From: David Margolis-Pineo
To: Jean Fraser
CC: Barbara Barhydt; Doug Roncarati
Date: 5/7/2014 3:17 PM
Subject: 421 Warren Ave
Attachments: WARREN AVE - 421 - PROPOSED SEVEN UNIT WAREHOUSE.docx

March 11, 2014

Memo To: Barbara Barhydt
Jean Fraser
From: David Margolis-Pineo
Re: 421 Warren Av
Commercial Site
PH Warren Avenue, LLC

**BOUNDARY SURVEY**

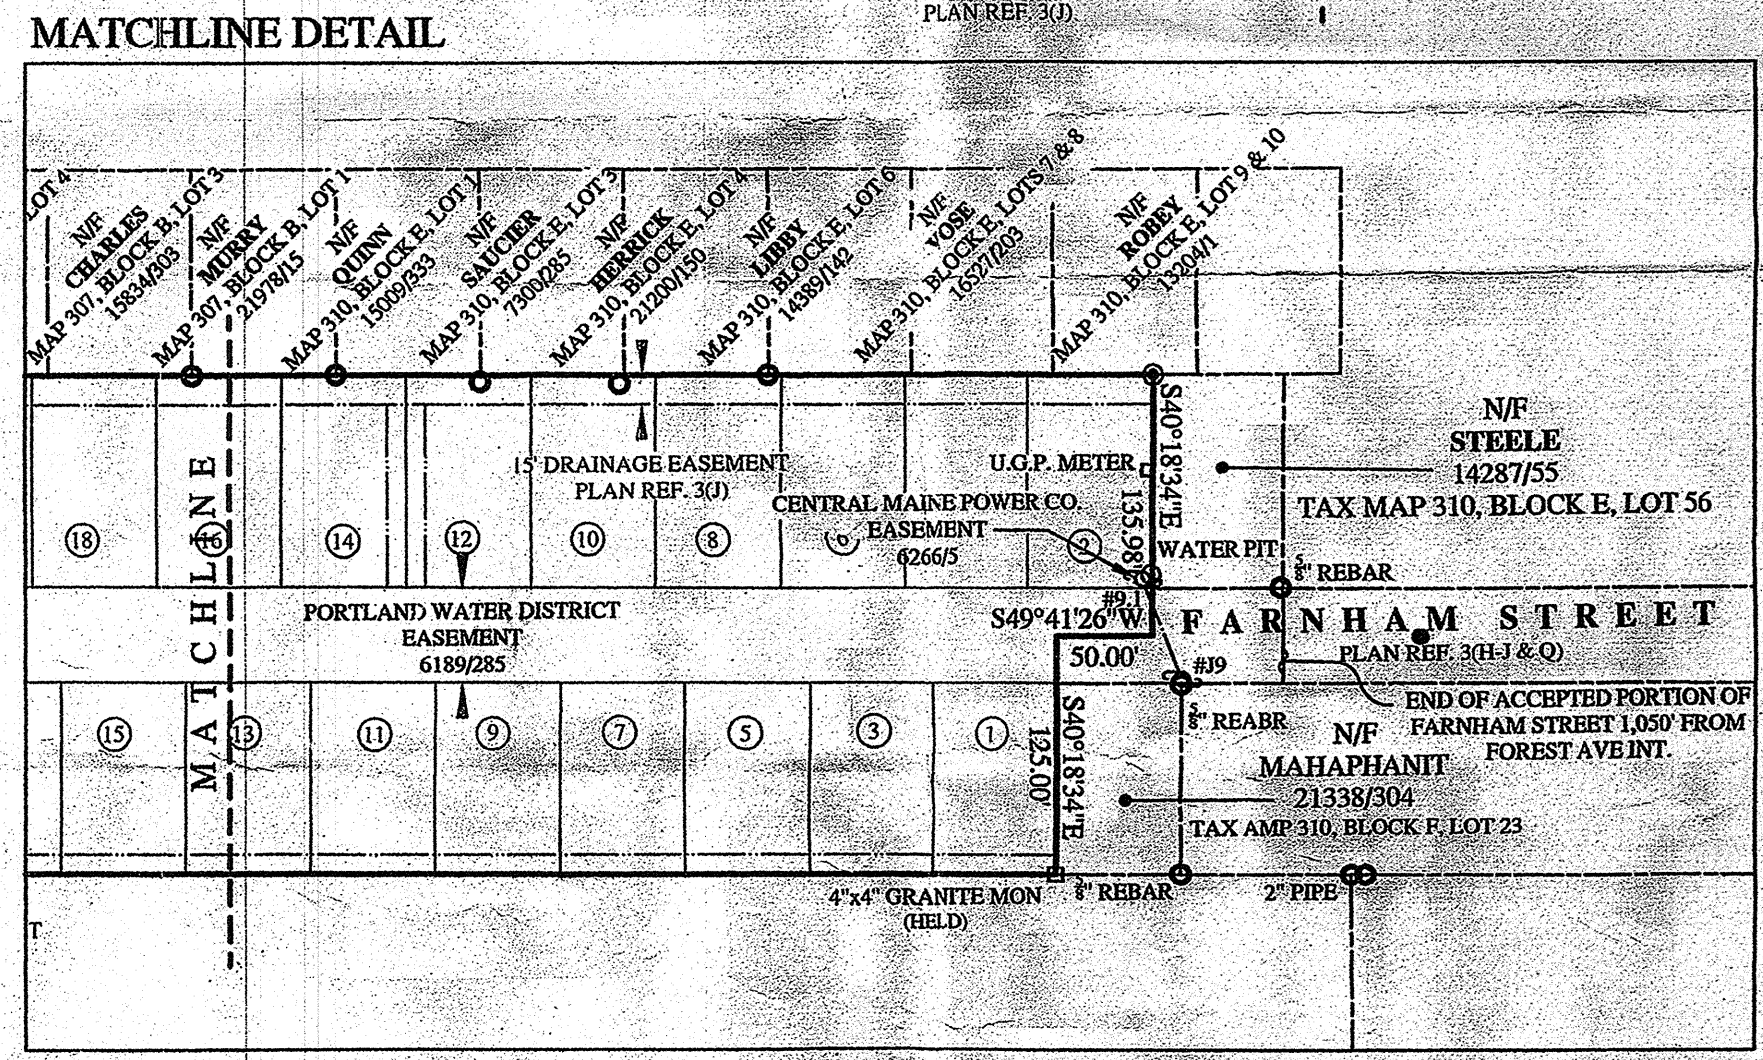
4. Please add State Plane Coordinates for four (4) corners; at both ends of the rear 657.94' line and at both ends of the 140.51' line along Warren Ave.

PROJECT PH WARREN AVENUE, LLC
SHEET TITLE SITE LAYOUT AND UTILITY PLAN

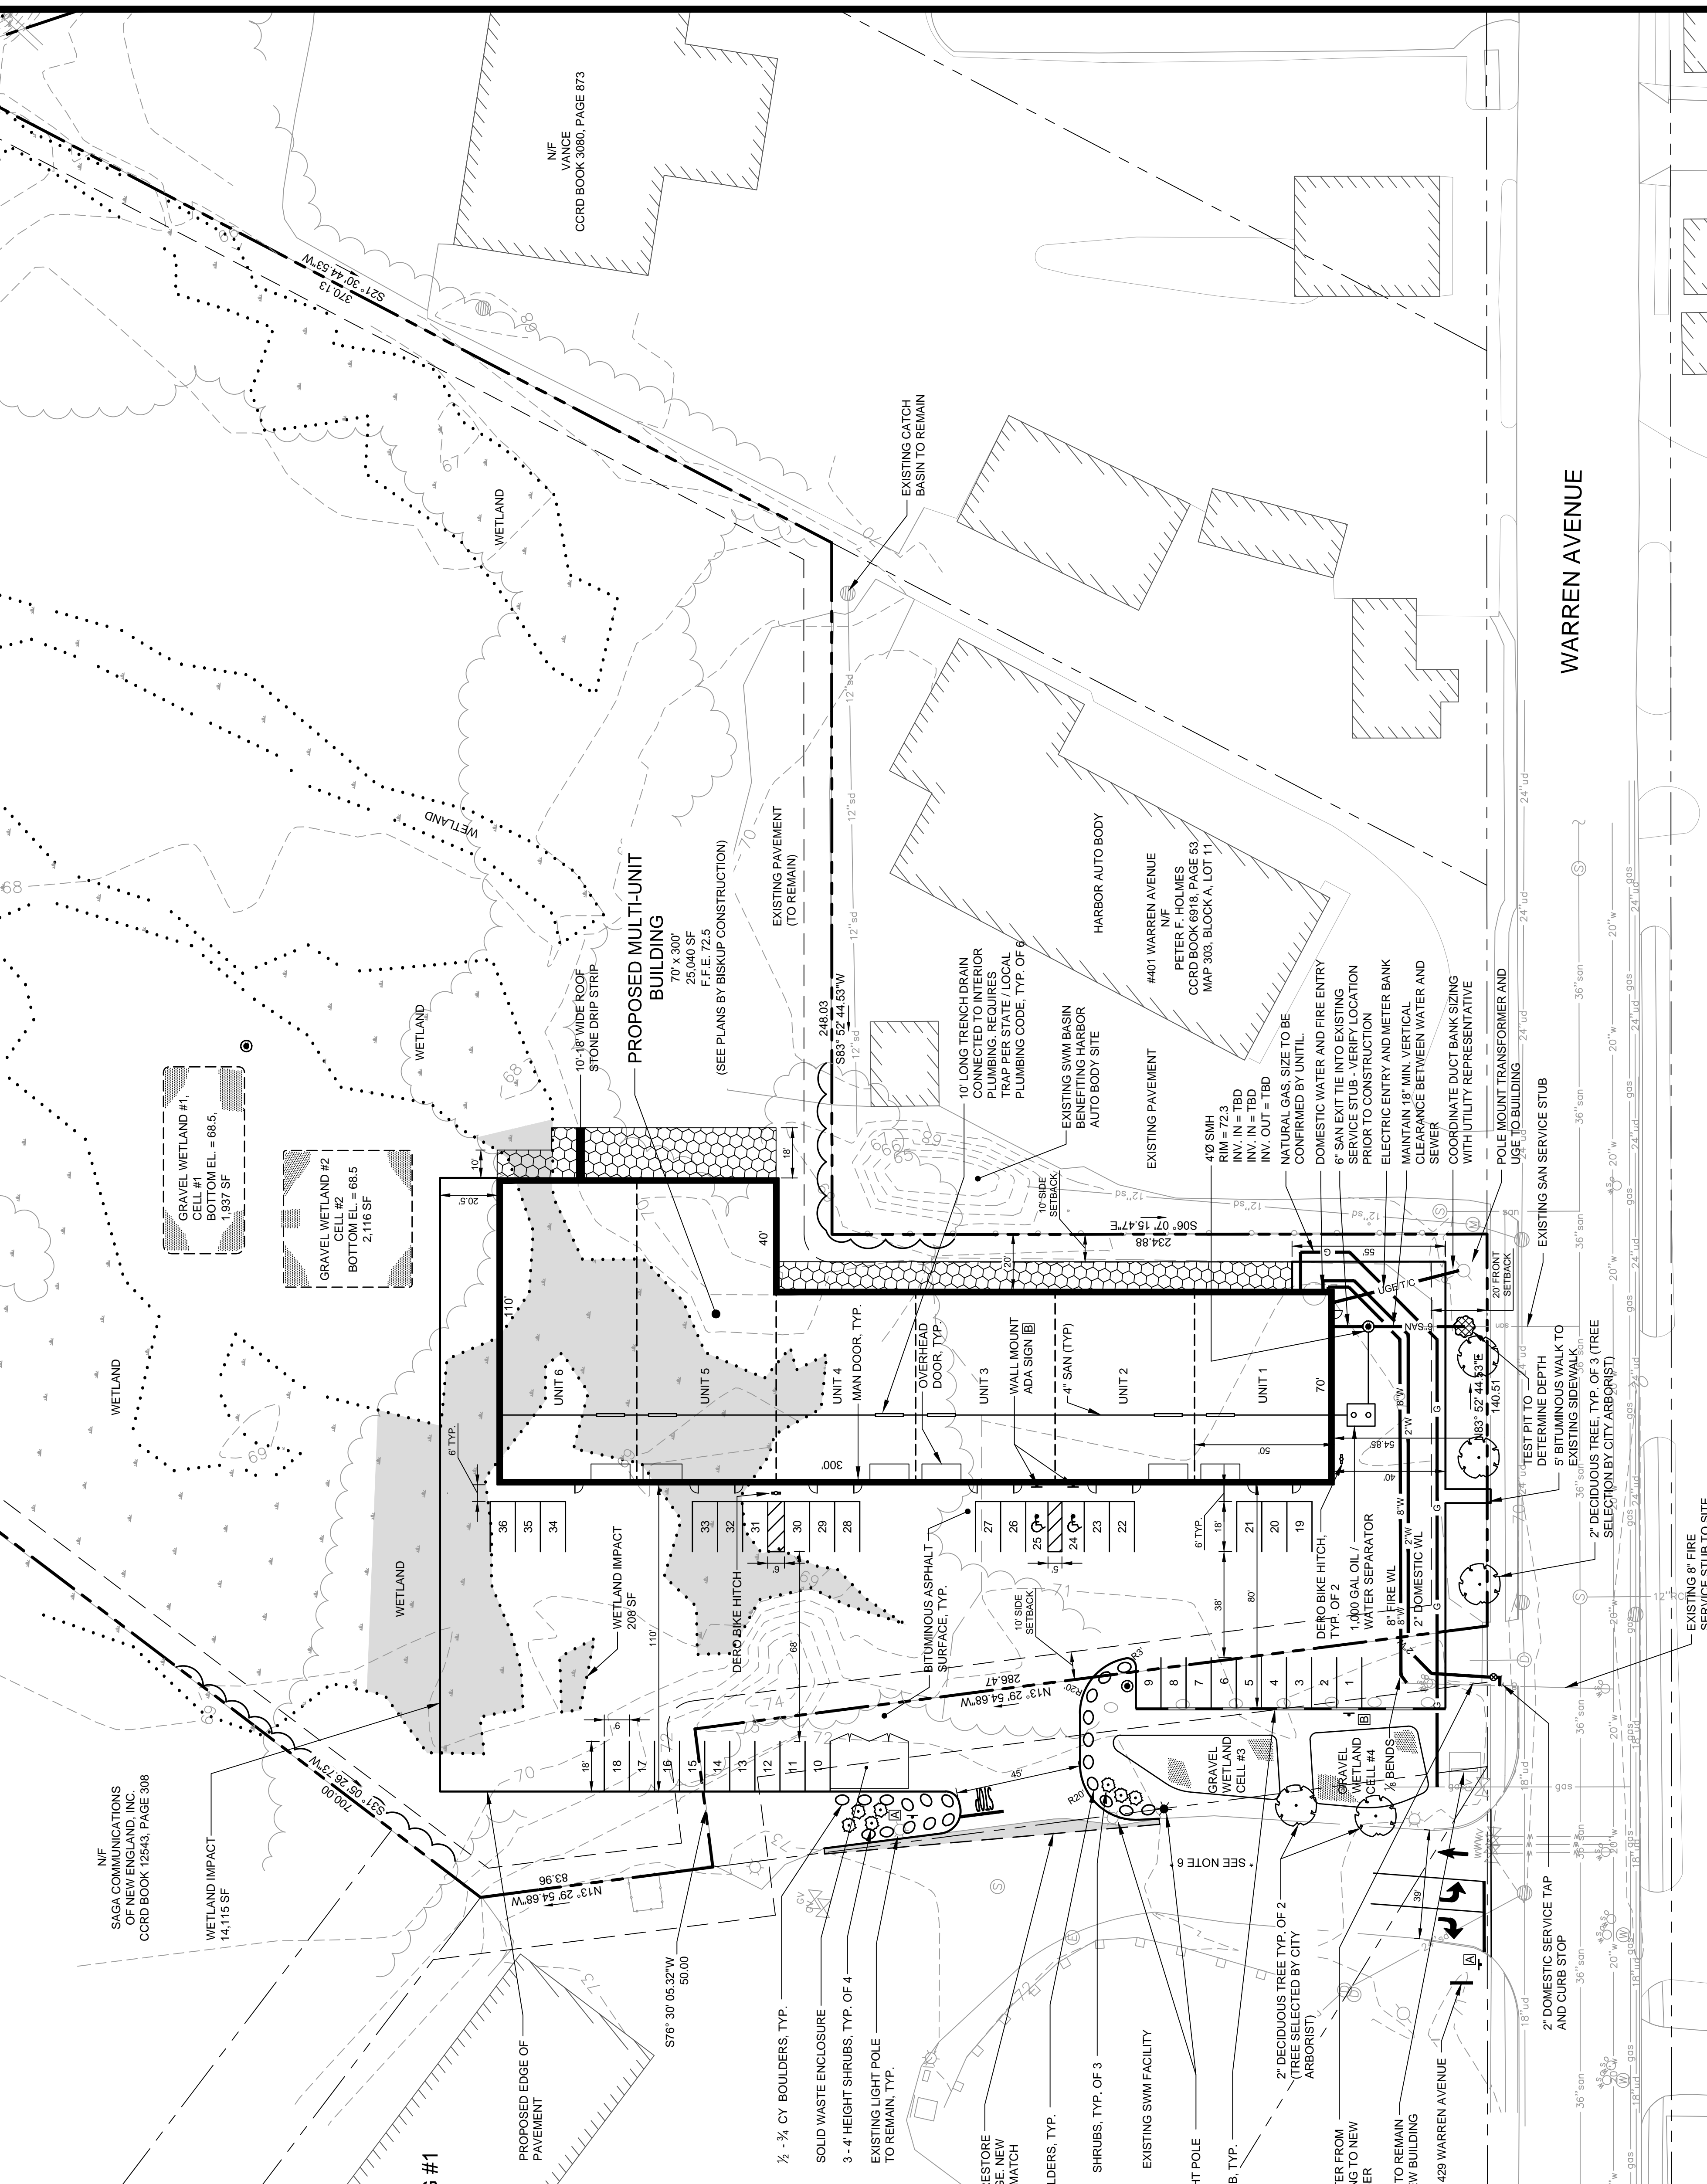
1. Since the curb cut on Warren Ave in front of this project is not proposed to be used, the applicant is requested to close the curb cut. The curbing shall be set in concrete to match the abutting curb work. Please contact Rhonda Zazzara for details. 874-8831
Warren Ave in this area is currently under a pavement moratorium until October 26, 2014. However as long as the applicant does not encroach the pavement more than two feet from the face of curb, no moratorium repair will be requested if the work is done before this date. A Street Opening Permit will be required.

2. It would be desirable for the applicant to tap for the 2" domestic water service behind the sidewalk to avoid cutting into the sidewalk.
3. Please note on survey plan that Saville Street and Newcomb Street are Continued Paper Streets as per City Council Order #84 in September 1997.
